# Appeal Decision

**Appeal Ref: APP/T2350/Y/24/3341288**

**29 Church Street, Ribchester, Preston PR3 3YE**

- The appeal is made under section 20 of the Planning (Listed Buildings and Conservation Areas) Act 1990 (as amended) against a refusal to grant listed building consent.
  - The appeal is made by Mr Thomas Ives against the decision of Ribble Valley Borough Council.
  - The application Ref is 3/2023/0577.
  - The works proposed are for a rear porch.
-

Fig 4. Proposed Rear Elevation

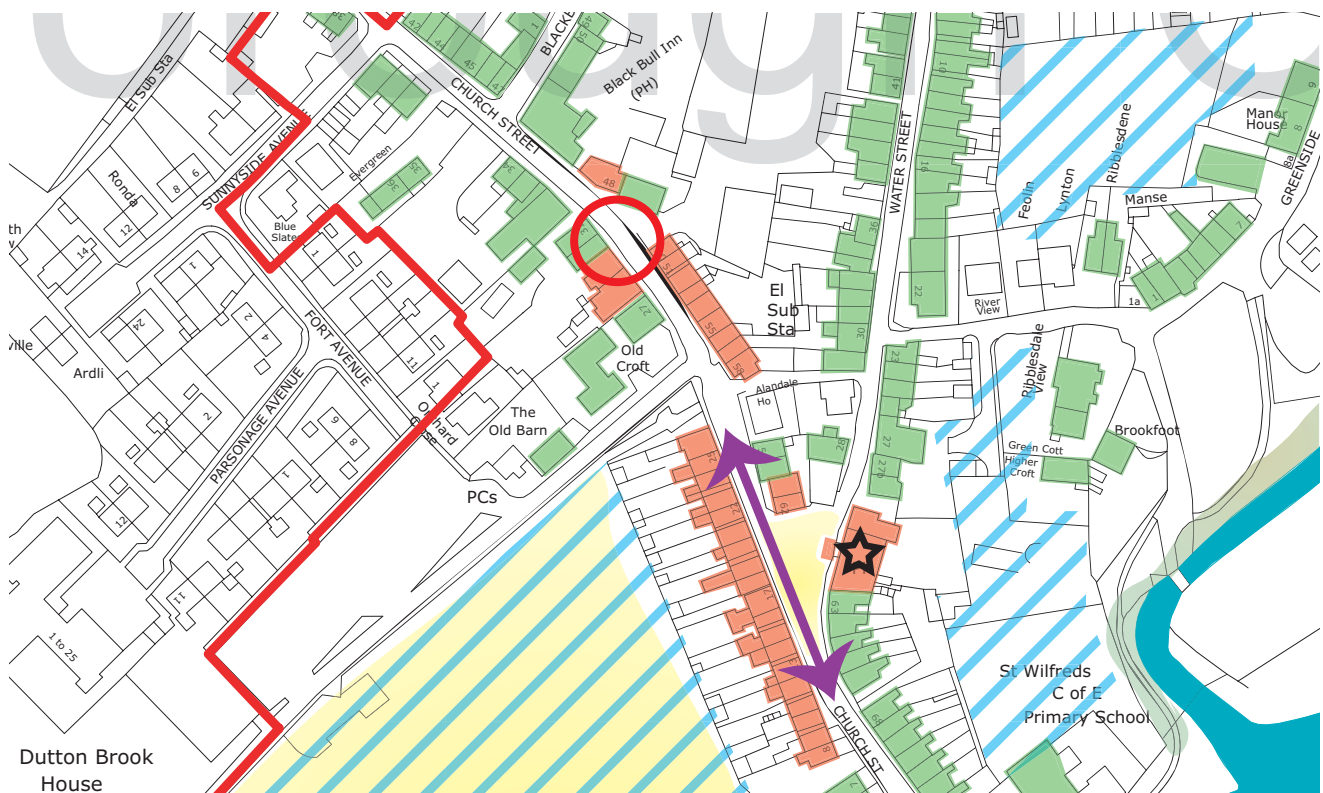
13. The proposed porch would be constructed of oak timber with a slate pitched roof. Whilst the slate roof would be reflective of materials used on the listed building, the thick oak timber framing would not. Its positioning would

obscure the attractive horizontal stone lintel above the rear door and the adjacent ground floor window. The ornate frame design and pitched roof would suggest a grand entrance, inconsistent with the simpler rear elevation. Moreover, the proposal's materials and design are more reflective of a rural farmhouse or barn rather than a polite Georgian residence. As an addition it would jar with the age and typology of the property and disrupt the identified status differentiation between the front and rear elevation.

14. Thus, the proposal would introduce a discordant feature that would draw attention away from the historic features of the building's rear elevation to the detriment of the designated heritage asset. It would undermine the authenticity and integrity of the asset and confuse the onlooker as to the building's narrative.

15. The appellant states that the proposed porch could be removed from the listed building with minimal evidence of its presence, requiring just fixing to the existing rear wall and flashing to seal the roof against the wall. However, I find the information regarding how the proposed porch would be attached to the rear wall is lacking in detail. Therefore, I cannot be certain that the proposal would not permanently damage the building's historic fabric. In any event, even if it was in this sense 'reversible', the identified harm would still occur whilst the porch was in situ.
